Hornsby Ku-Ring-Gai Hospital Stage 2 – State Significant Development Project (SSD 8647)

Request for Additional Information
NSW Health Infrastructure
1 May 2018

Request for additional information – SSD 8647 – HKH Stage 2 Redevelopment

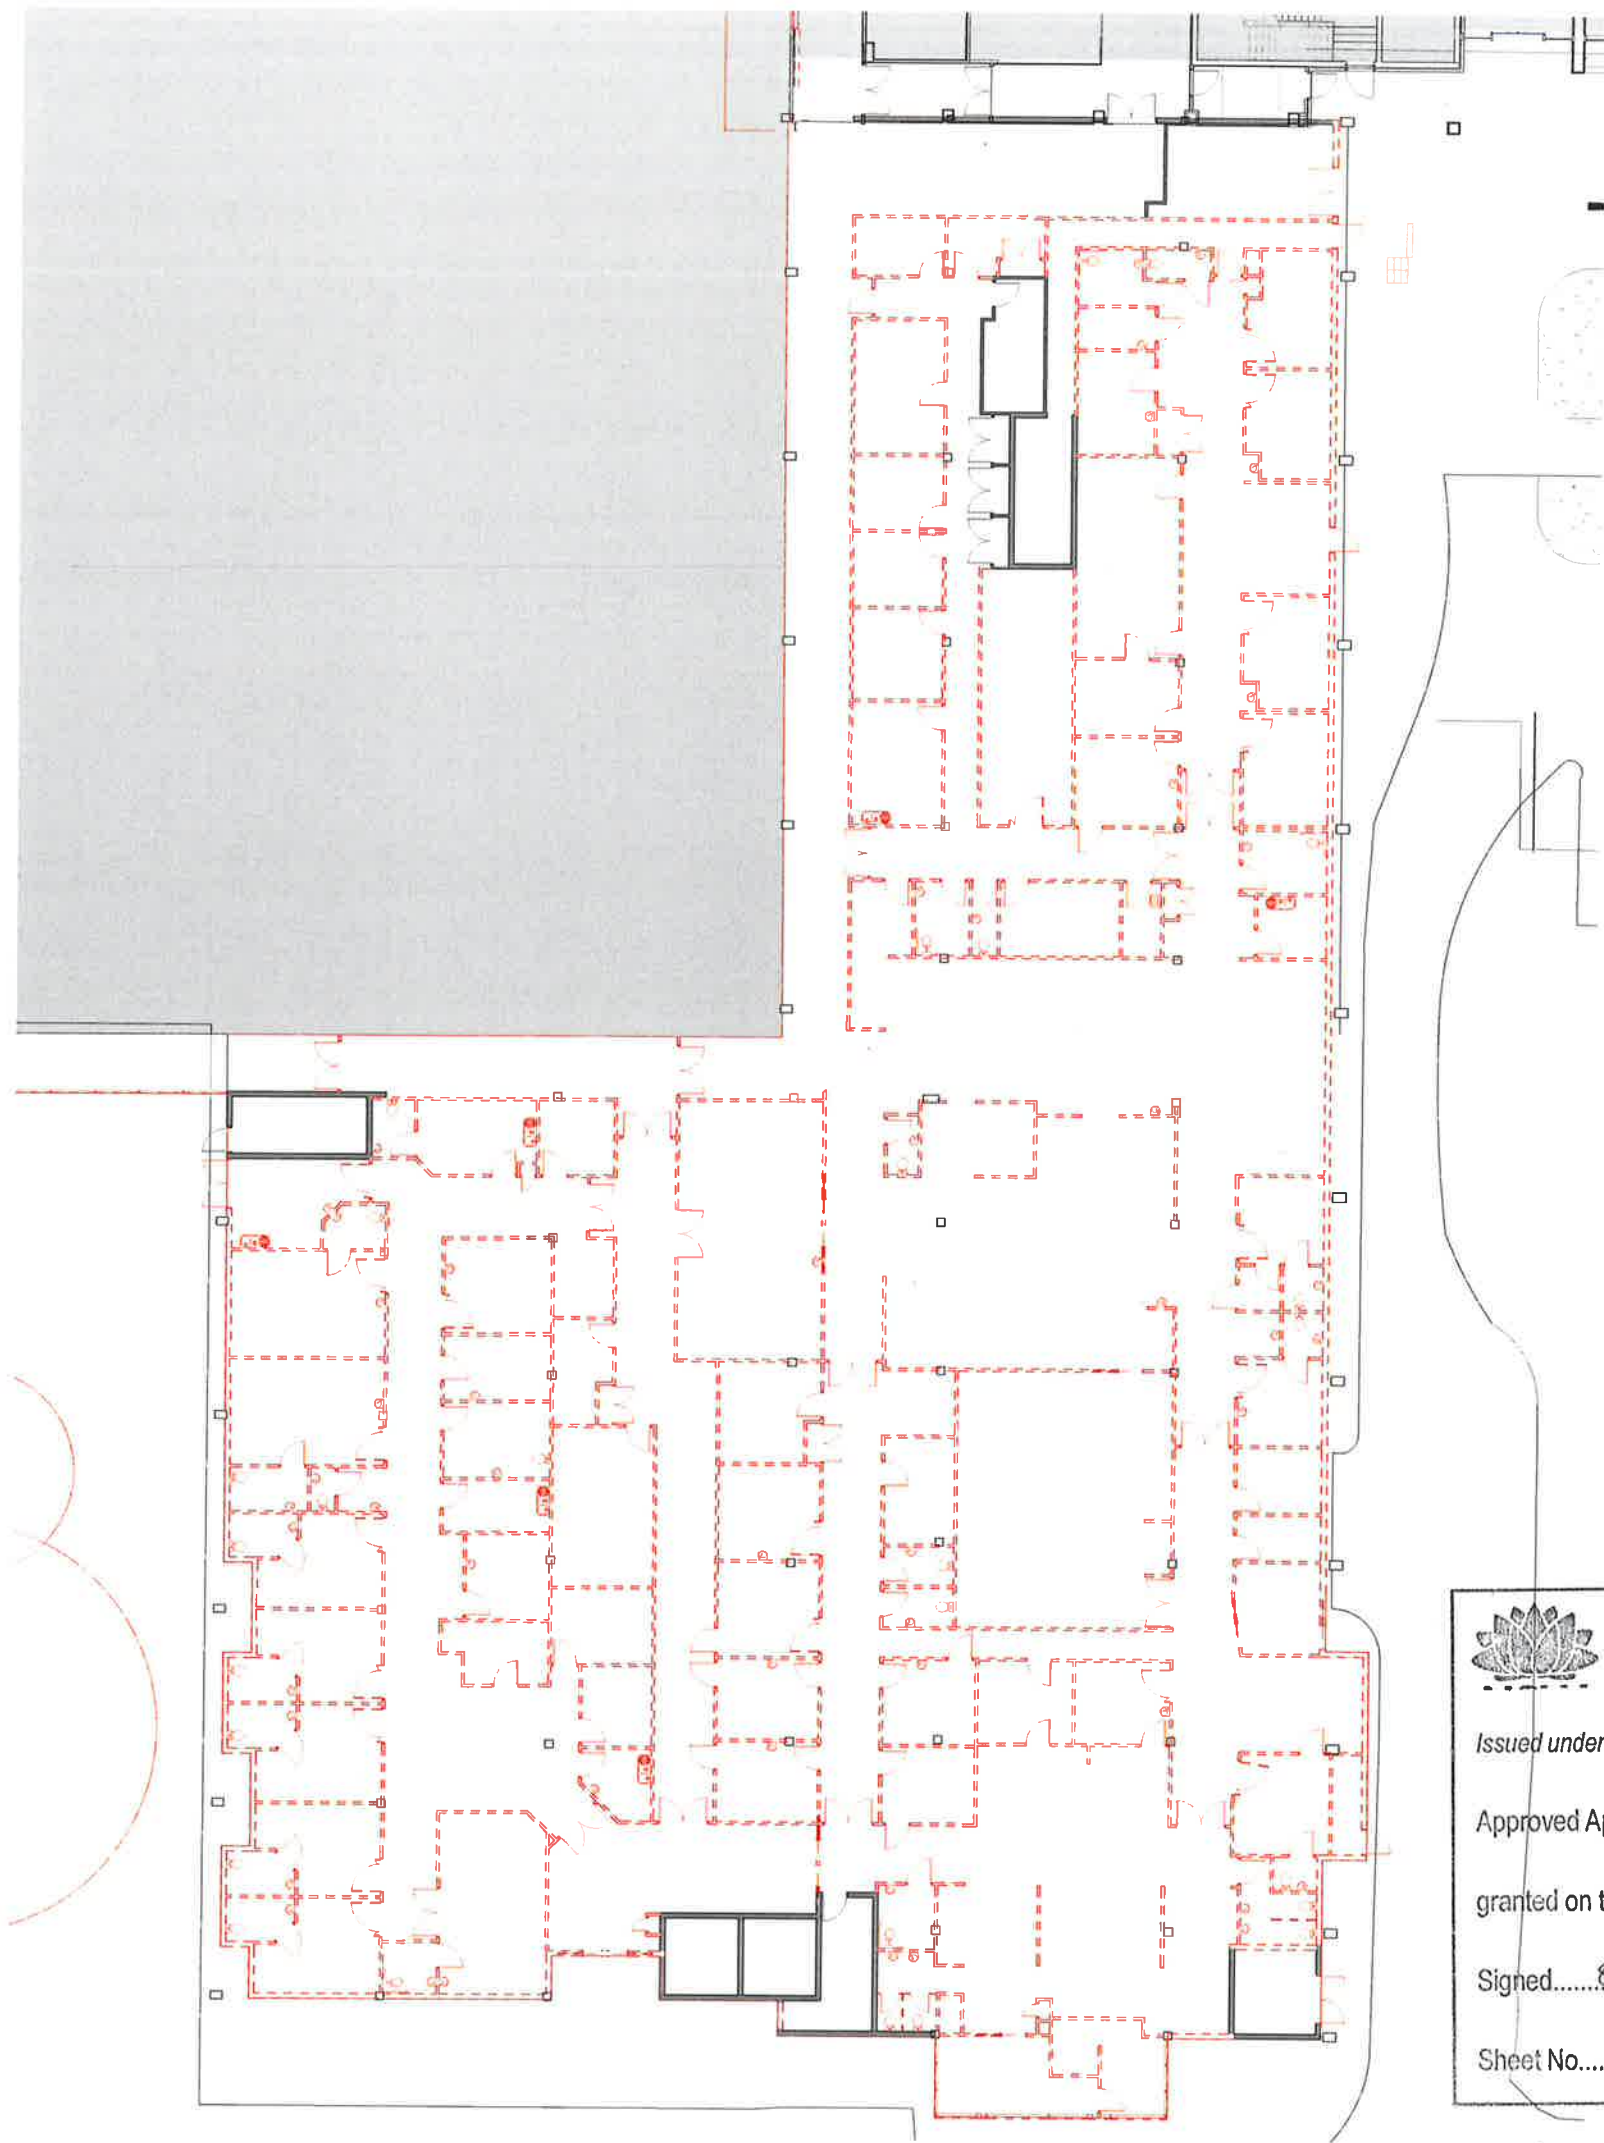
1.6	Department of Planning and Environment	Demolition Plan Please update the demolition plan to reflect the list of buildings identified for demolition in the RtS-2 as this plan will form part of the consent if granted.	Please refer to the revised Demolition Plan under Appendix D.	Appendix D – Revised Demolition Plan
